16 March 2007

**REQUEST FOR KEY ISSUES AND ASSESSMENT REQUIREMENTS - PROPOSED STAGED MIXED USE RETAIL, COMMERCIAL OFFICE & RESIDENTIAL DEVELOPMENT, INCLUDING THE PROPOSED MAJOR REDEVELOPMENT & UPGRADING OF THE CROWN CENTRAL SHOPPING CENTRE COMPLEX  
YOUR REF: MP 06-0209 S06/00441**

**PROPERTY: PART OF KEIRA STREET ROAD RESERVE, PART OF RICHARDSON STREET ROAD RESERVE, PART OF CROWN LANE ROAD RESERVE, LOT 1, DP 823263, LOT 260, DP 823263, LOT 270, DP 8473, LOT 250, DP 823262, LOT 1, DP 503512, LOT 100, DP 568649, LOT 7, DP 521621, LOT 1, DP 510608, LOTS A & B, DP 403097, LOT 1, DP 797590, LOT 1, DDP 799494, LOT 100, DP 734993, LOTS 1 & 2, DP 17888 AND LOT 1, DP 154592, GENERALLY BOUNDED BY CROWN STREET, KEIRA STREET, MARKET STREET, CHURCH STREET, BURELLI STREET, RICHARDSON STREET, CROWN LANE & REGENT STREET, WOLLONGONG**

Figure 4: Ground floor layout - proposed

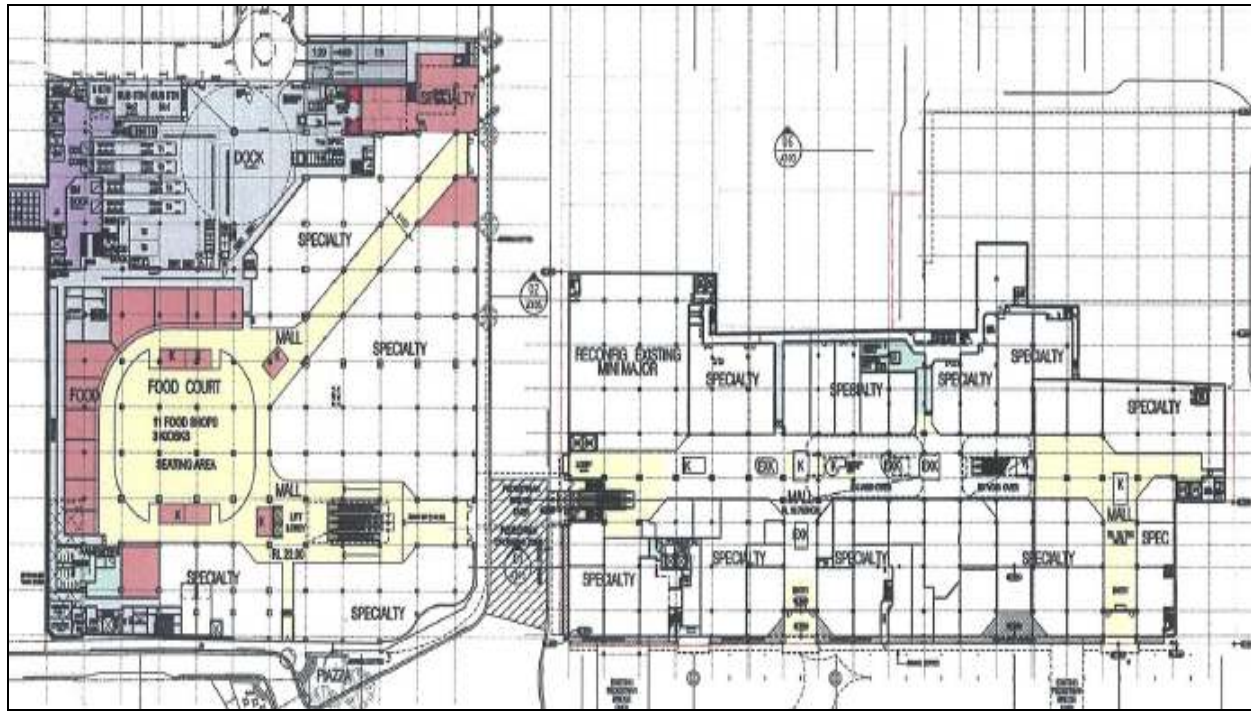
All specialty shops located at ground floor should have individual entrances to the street to promote pedestrian activity especially along Crown Lane and Crown Street Mall. Entrances from Keira Street should be provided to the Mini Major department store which also provides access to the major department store. Specialty shops should be continuous along street frontages. Improvements can be made in providing street access from Crown Lane to the specialty shops to open up the lane and make it more usable as it is currently underutilised with vandalism and loitering of people.

Figure 12: Cross section view of **proposed** 9.4m wide bridge

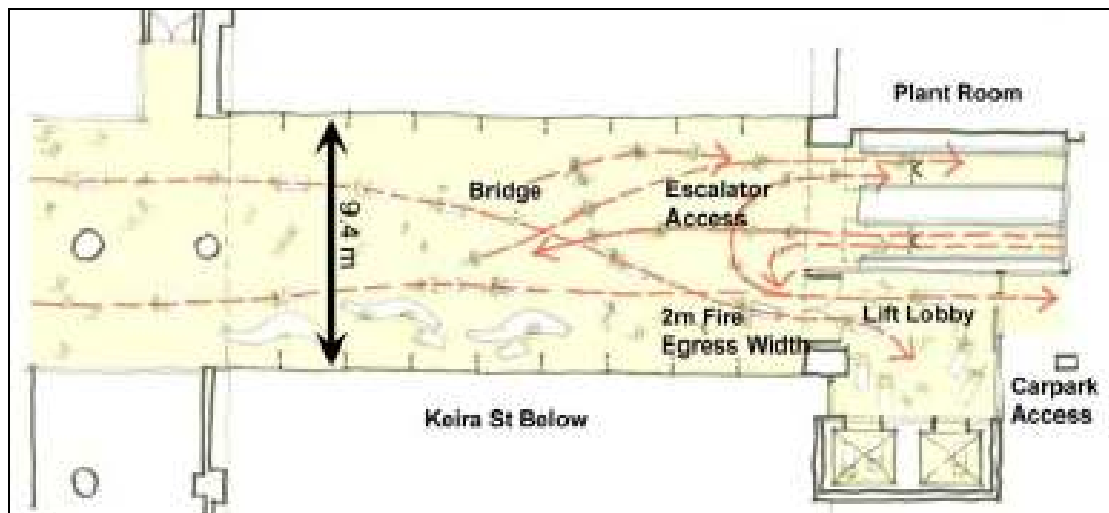
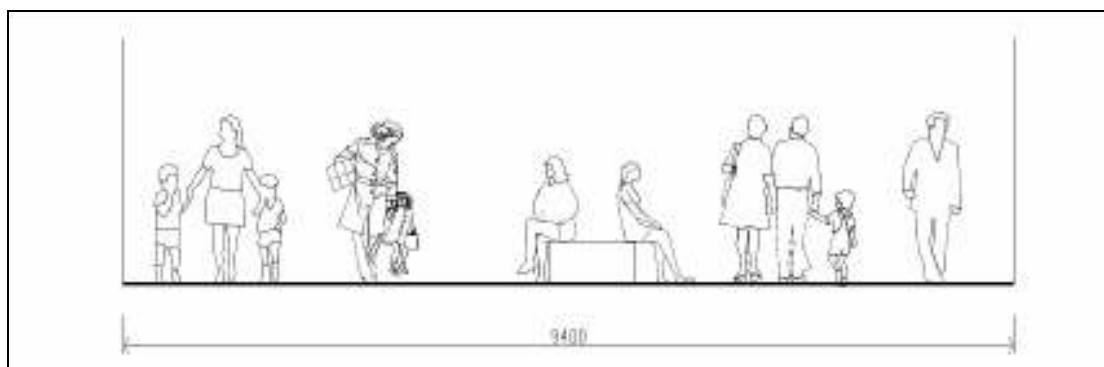
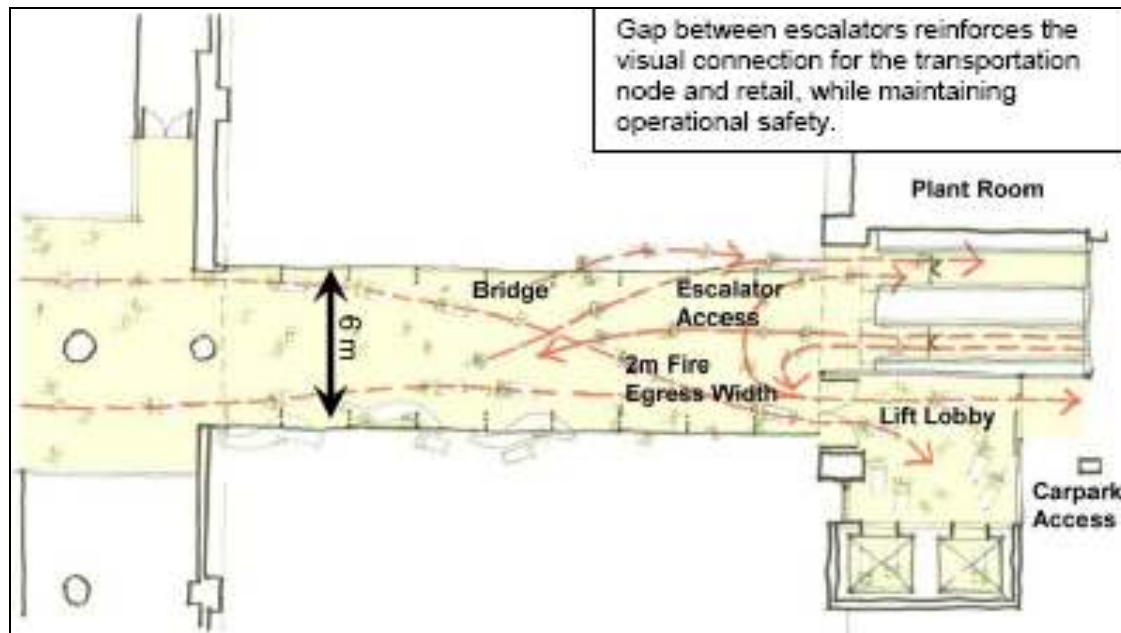
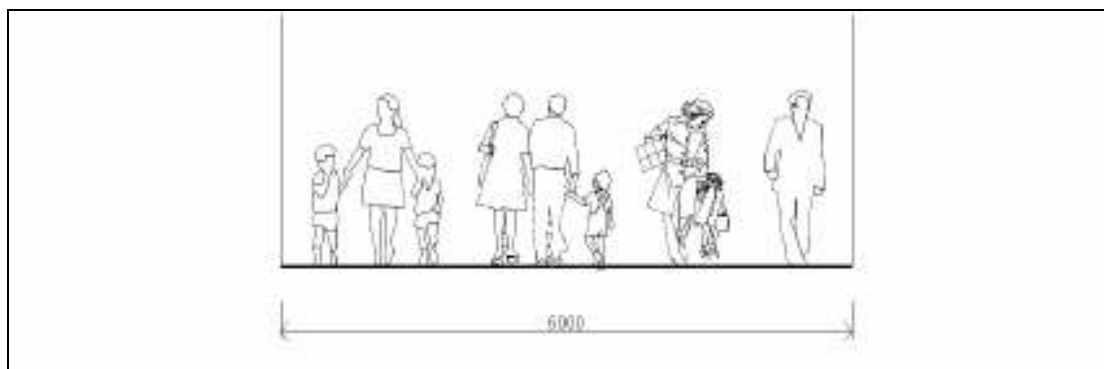
8. The proposed pedestrian overbridge above Keira Street (linking the eastern Crown Central shopping centre with the western Keira Street retail podium) is required to incorporate a minimum 5.8 metre clearance height above the road carriageway to ensure buses and other heavy vehicles are able to continue to travel along Keira Street. The 5.8 metre clearance height requirement is requested to be reflected on Development Application elevation and sectional plans together with appropriate RLs.
